**MP 11_0044 COMMERCIAL BUILDING C3 PROJECT APPLICATION
RESPONSE TO AGENCY AND PUBLIC SUBMISSIONS**

City of Sydney		
1	<p>Previous (February 2011) Recommendation 1 - The proponent must provide drawings that document the location of the building. For example, a dimensioned plan showing the Blocks relative to the site boundaries and a dimensioned plan showing C4 within Block 2. This is to include the location of Hickson Road, its kerblines and its existing fig trees.</p> <p>Generally satisfied although Hickson Road details remain sketchy.</p>	<p>Noted. It is not agreed that details at Hickson Road remain sketchy. Drawing RHSP-A-C5-2200-P-00 is a scale drawing that shows the location of Hickson Road, its kerblines and its existing fig trees in the context of this proposed building and its site. See also section 3.7 of the PPR</p>
2	<p>Previous (February 2011) Recommendation 2 - The proponent must provide sections which show how the forecourt successfully changes level from RL 3.6 to (average) RL 2.2, and document why this level change is required.</p> <p>DP&I should ensure that all alignment levels for new areas of public domain are designed to integrate with the existing public doma

**Figure 2** – Commercial Building C3 pedestrian circulation

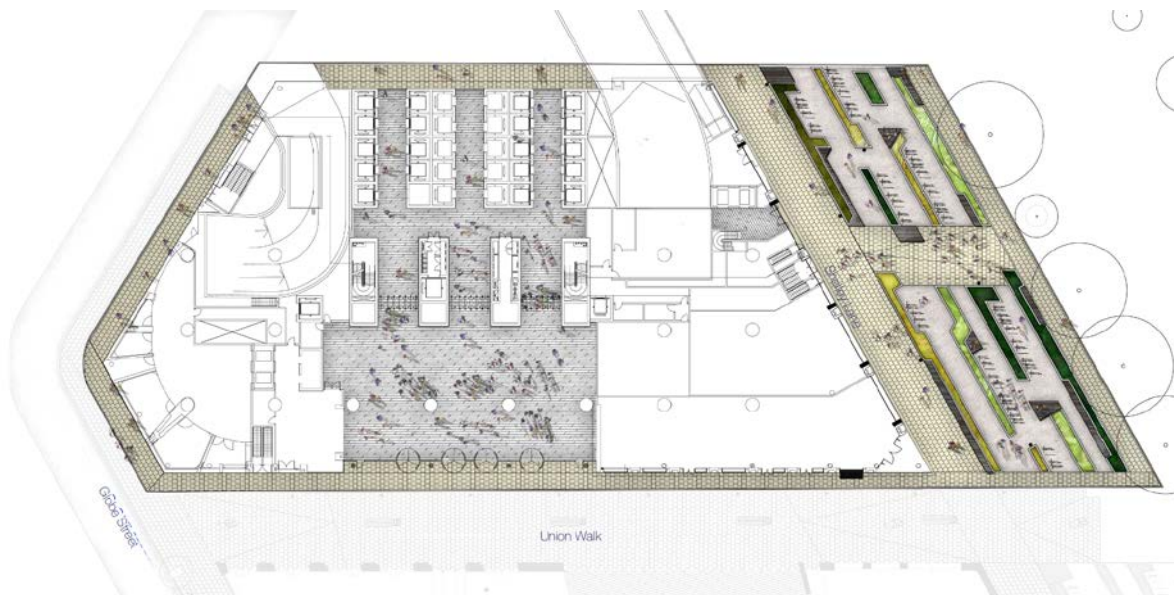
5	Section 4.9 - There are no details provided on pedestrian access and circulation. Figure 12 is missing a key and provides no information. Further detailed information on pedestrian access and relationship to public domain is required.	Figure 12 provides a representation of the key pedestrian approach routes to Commercial Building C3, and supports the text in the preceding paragraph. Detailed circulation arrangements within Commercial Building C3 and the basement will be provided during the project design phase.
6	<p>Section 4.10 and Appendix D - There is very little detail on the solution for bicycle parking requirements for the development, and the relationship to adjacent development. It appears that there is a single very small shared facility in the basement.</p> <p>The facilities as proposed appear inadequate for the stated number of bicycle spaces. There is no commensurate provision of facilities for cyclists within the building floor plates, or explanation and scoping of facility requirements. There are no details on bicycle access from the adjoining street networks. The maps provided in the supplementary TMAP are general in nature.</p> <p>More details are required on the strategy for bicycle access and facilities. The proponent should address the long term bicycle parking requirements.</p>	The current application includes spatial provision for bicycle parking and associated end of trip facilities for 5% of all commercial employees in accordance with GreenStar requirements. Lend Lease is targeting the provision of the facilities for 10% of all commercial employees subject to spatial considerations.
